Nunnerley House Farm Leaveslake Drove West Pinchbeck Spalding PE11 3QJ

H14-1288-25

03/02/2026

After reviewing the proposal in full, I recommend that the application be refused on the basis of Policy 23 of the South East Lincolnshire Local Plan (2011–2036): The Reuse of Buildings in the Countryside for Residential Use. This policy establishes five criteria that should be met for the residential conversion of an existing building to be supported by the Local Planning Authority.

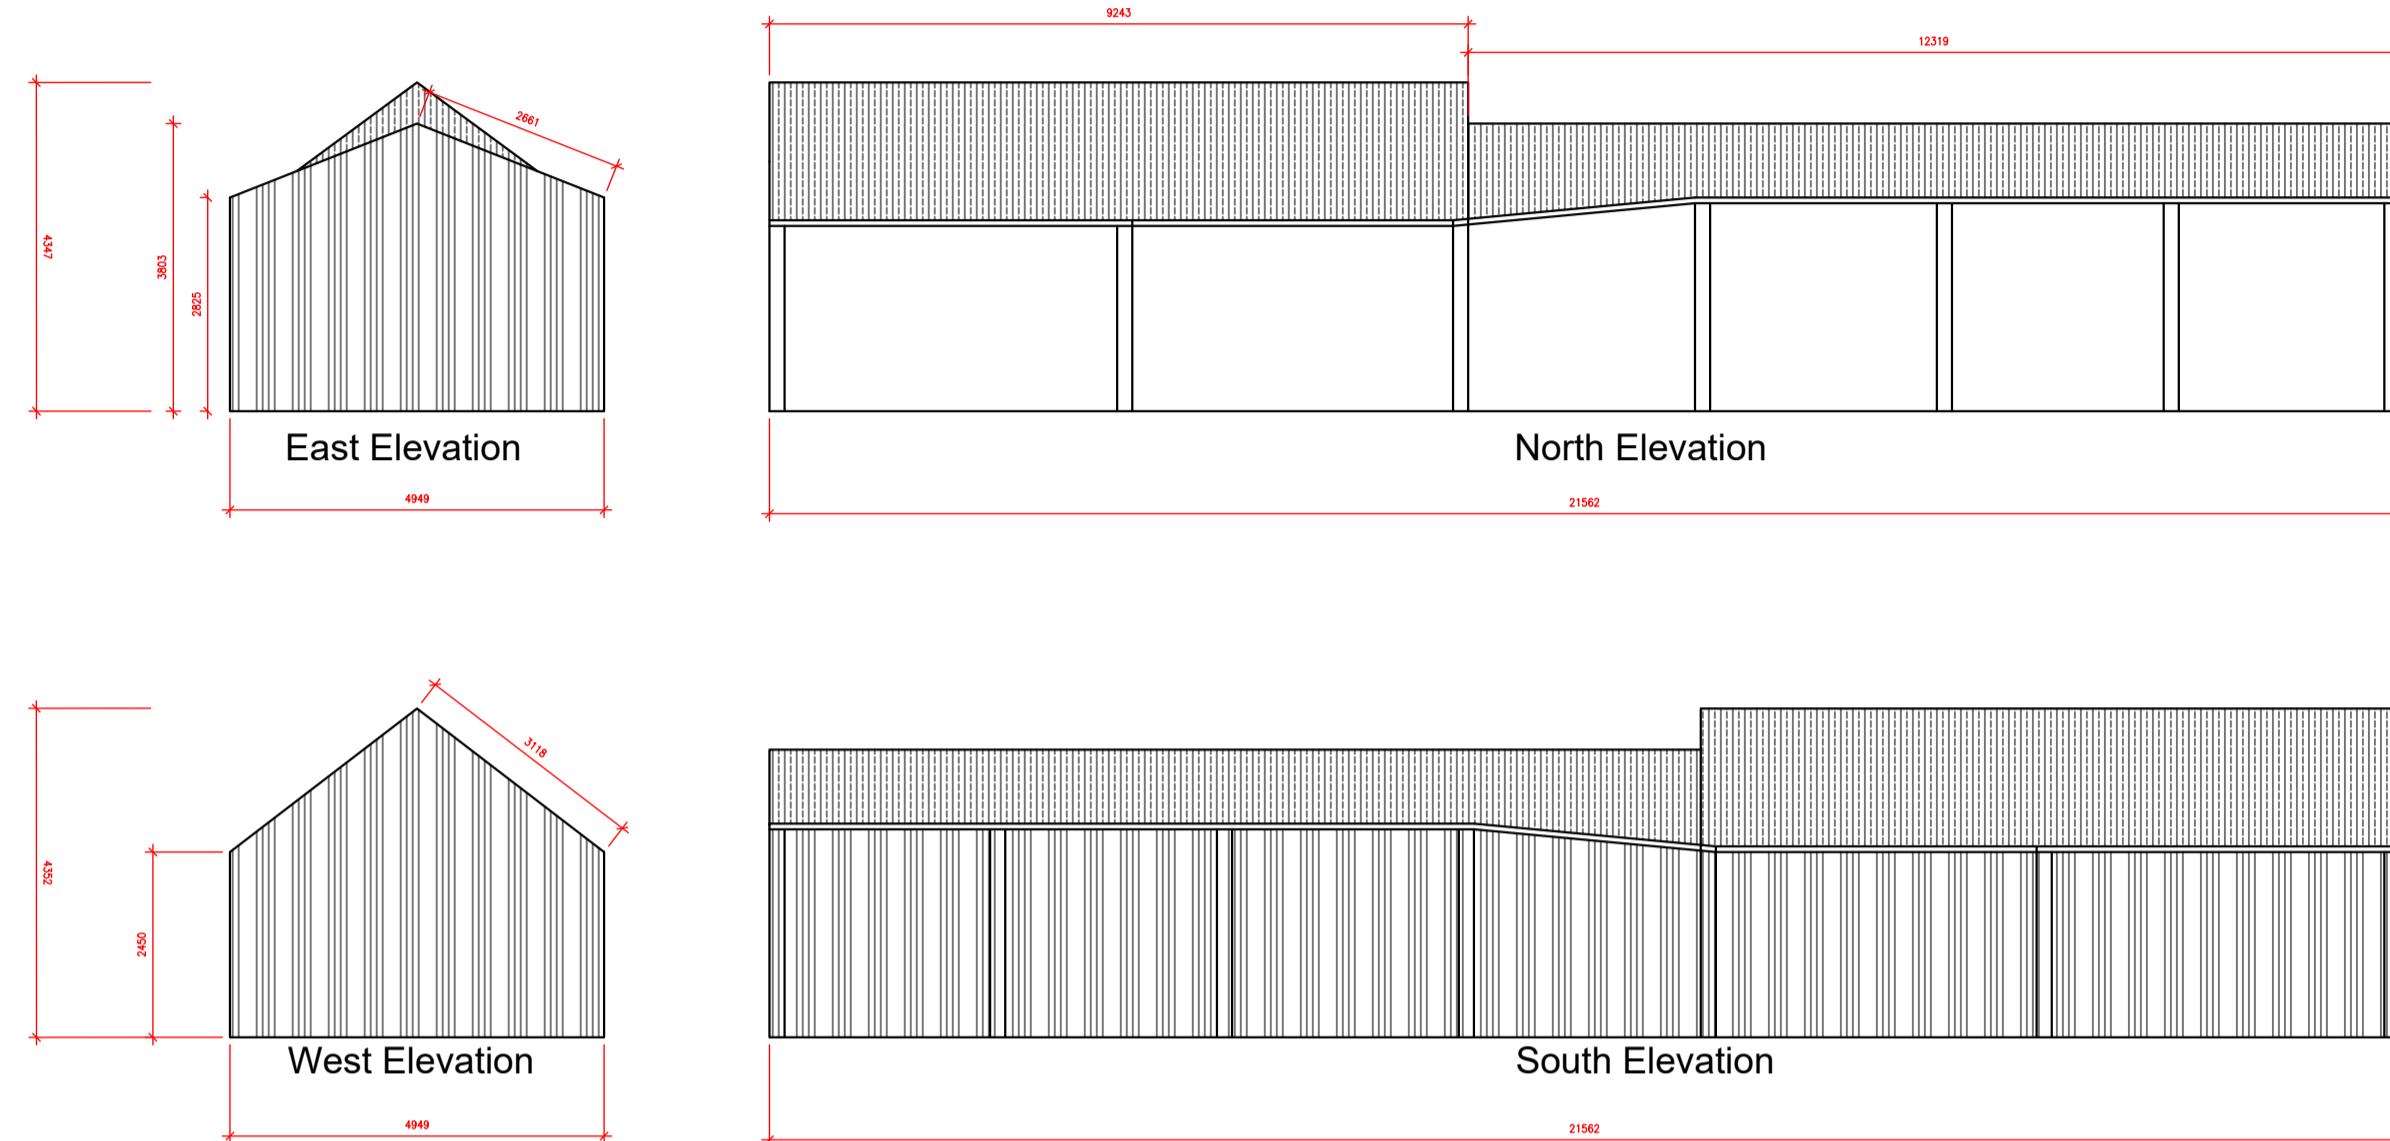
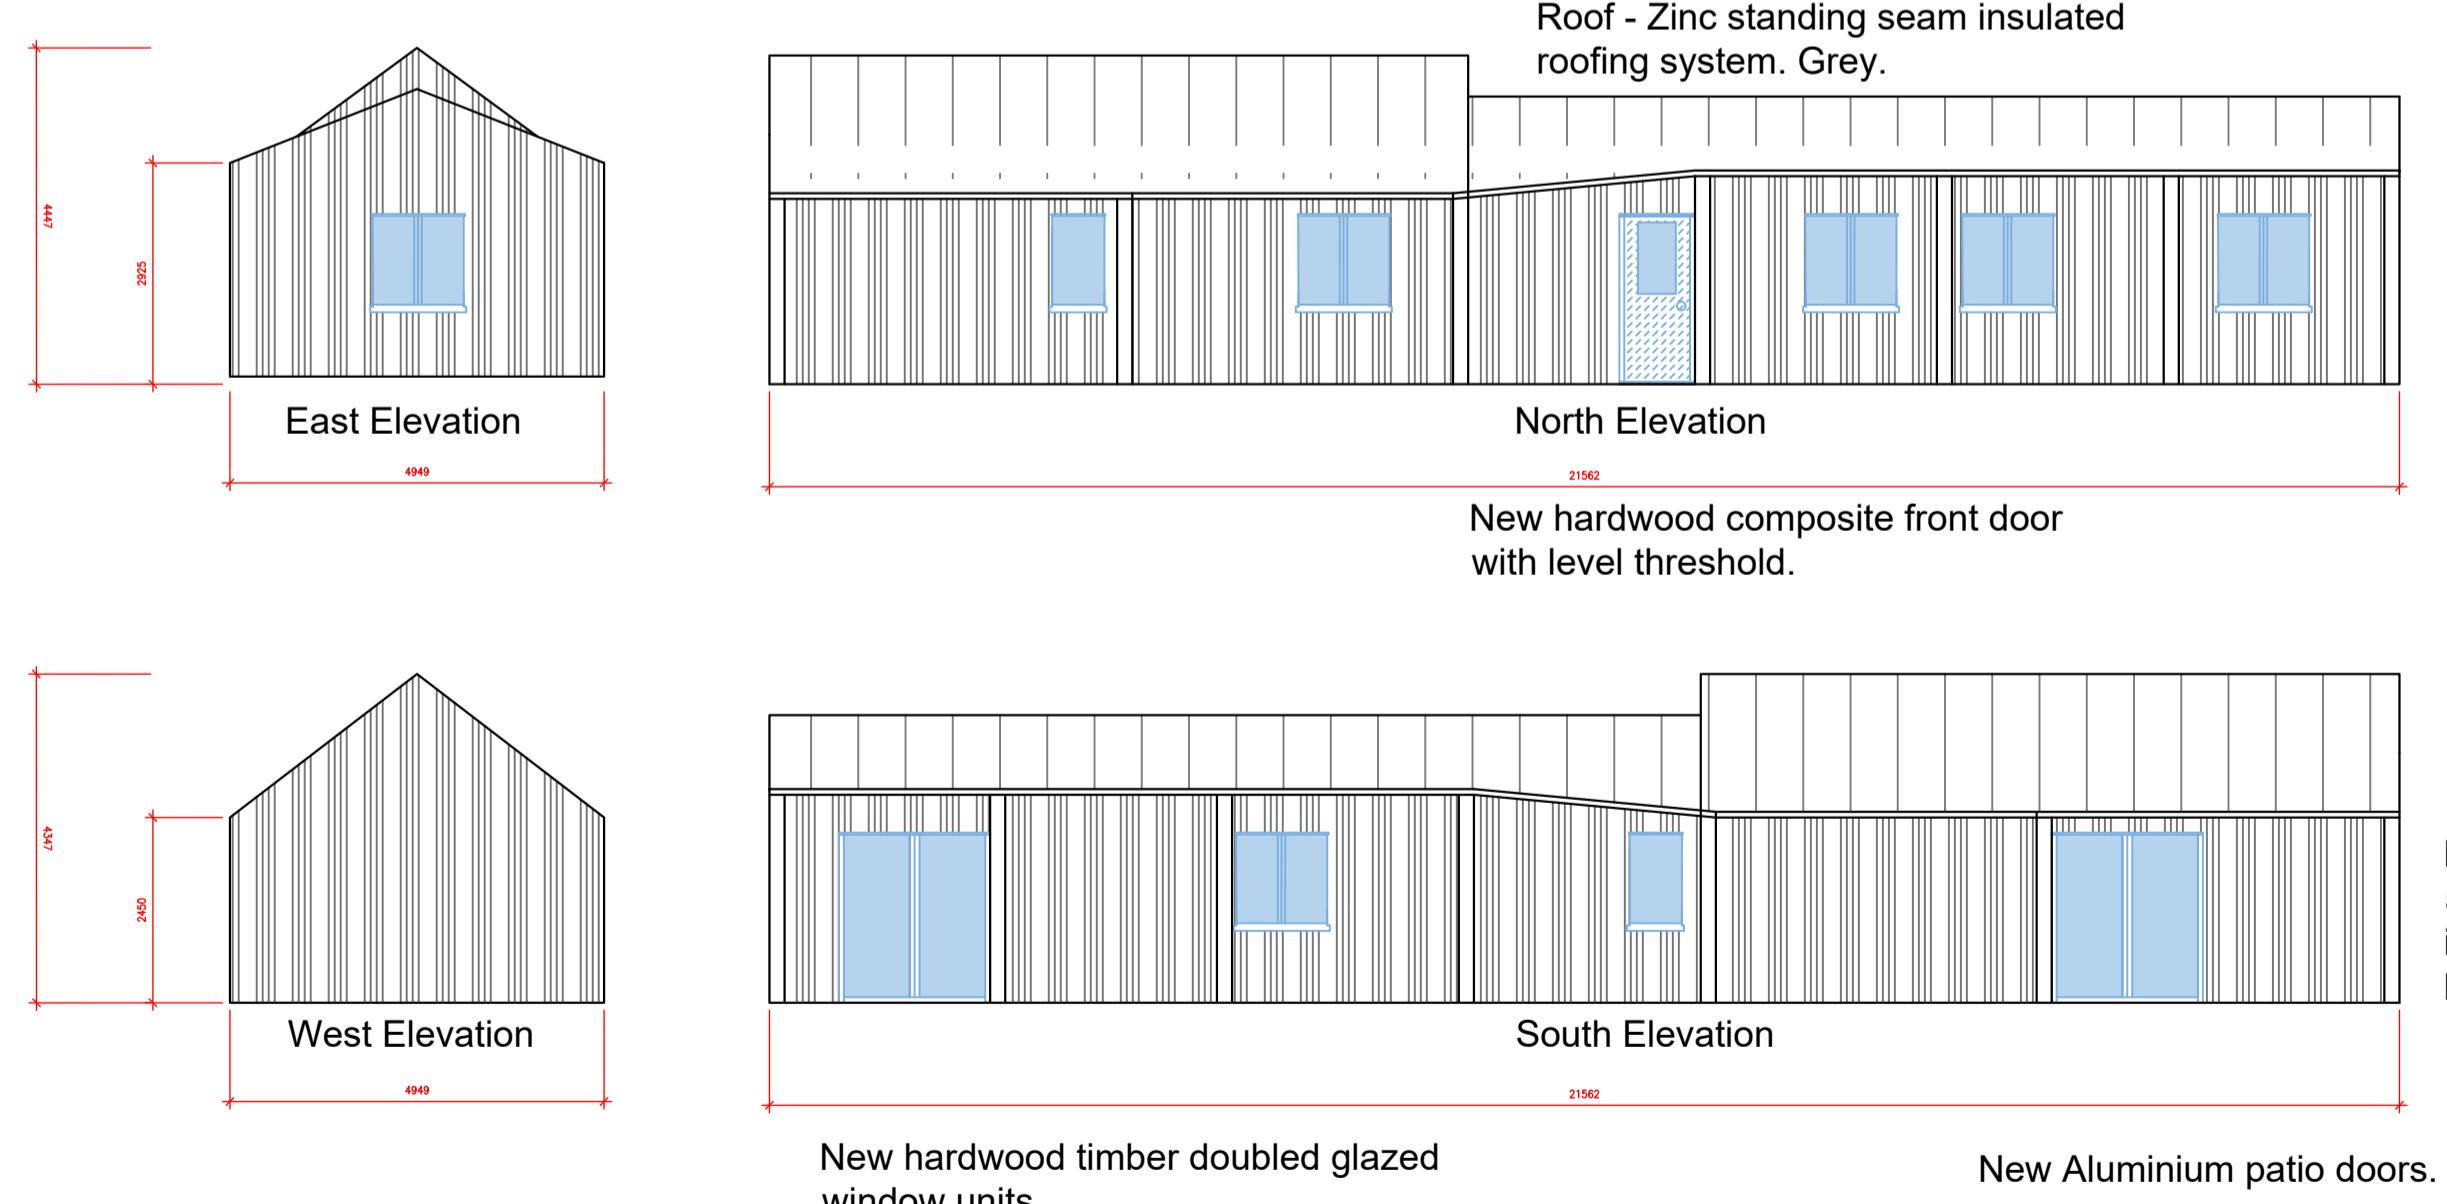
The barn identified for conversion would require extensive works, including the installation of an entirely new roof, the complete enclosure of the northern elevation, external cladding, and the insertion of multiple new openings across the remaining elevations. In addition, the submitted information indicates that a number of structural timbers are either damaged or decayed and will need repair or replacement, although the exact number for this intervention is not supplied.

The design as submitted would significantly alter the appearance and character of the existing barn through the introduction of modern materials and a substantial number of new window and door openings. These interventions would remove the agricultural character of the structure and replace it with a more modern and domestic appearance. Consequently, the converted building would fail to make visual sense within its rural context and historic setting.

The proposed replacement materials, combined with the degree of alteration required, would result in a building with a more polished and modern appearance that bears little resemblance to the original structure. This conversion would significantly change the

buildings character to an extent that it is unlikely to retain any agricultural qualities/ character.

The proposed conversion would undoubtedly improve the building's physical condition; however, the introduction of new materials, domestic openings, and a more refined finish would significantly alter its character. The resulting structure would appear overly modern and not agricultural in character, meaning it would no longer relate to the surrounding rural context.
